**REQUEST**

Current Zoning: CG (general commercial) and N1-A (neighborhood 1)  
Proposed Zoning: R-8MF(CD) (multi-family residential, conditional)

Approximately 13.02 acres located on the south side of Albemarle Road, east of Manchester Lane, and west of Wilgrove-Mint Hill Road.

The petition proposes to develop the parcel in east Charlotte, with up to 60 single family attached dwelling units accessed off private alleyways connecting to a new public street through the site.

RZ-1.0

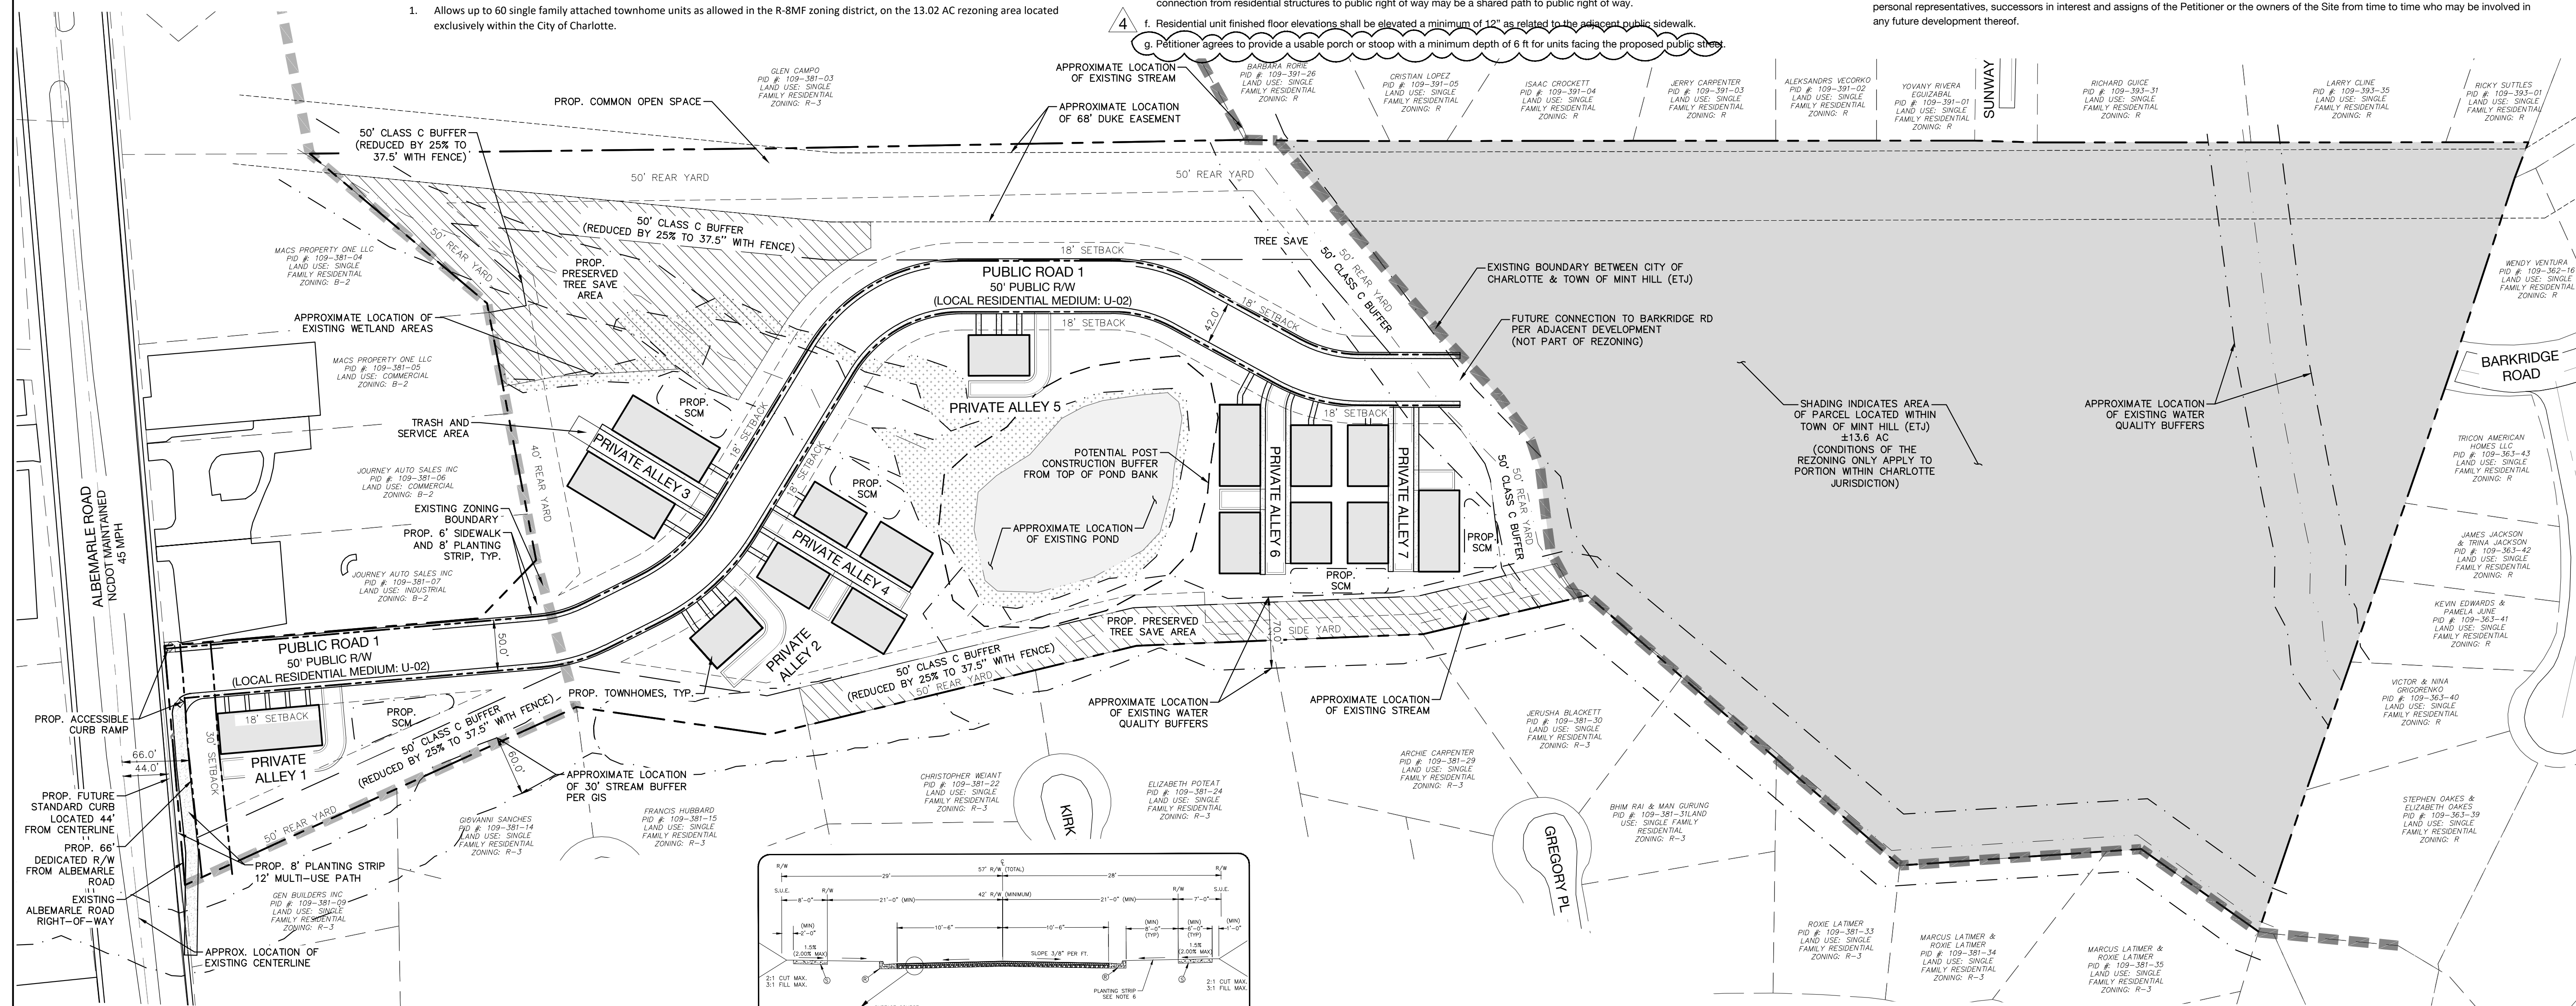
1. ~~Adjust setbacks to be measured from the full R/W of a U-03A street type per CDOT memo.~~ **Rescinded, due to CDOT rescinded comment #10.**
2. ~~Show the Ordinance required buffer along the rear of parcels ending in 38107, 38106, 38105.~~ **Addressed**
3. Staff requests a note be added limiting the maximum number of units per building to 4. **Not addressed**
4. Provide an architectural note committing to the provision of a usable porch or stoop at least 6 ft feet for units facing the proposed public street. **Note added but needs minimum depth.**
5. Provide an architectural note describing the pedestrian entrance at the end of buildings (on the either side of Alley 3 for example). Confirm if that is the entrance to the building or to the individual end unit. **Not addressed**

6. Amend Permitted Uses Note 1, to say "Allows up to 60 single family attached townhome units as allowed in the R-8MF zoning district on the 13.02 ac rezoning area located exclusively within the City of Charlotte." **Not addressed**

7. Show, label and dimension the stream buffer that per GIS is a 30 ft stream buffer located along the northwest property line. **Not addressed**

13. Remove proposed density from the development data table. Change Max Density to "Max Allowed Density" and adjust the numbers to match number of units (60) proposed and the density of 4.6 accordingly. The max and proposed units/density are the same with the conditional zoning. **Not addressed**

19. **Show pedestrian curb ramp on plan north side of corner of Public street 1.**
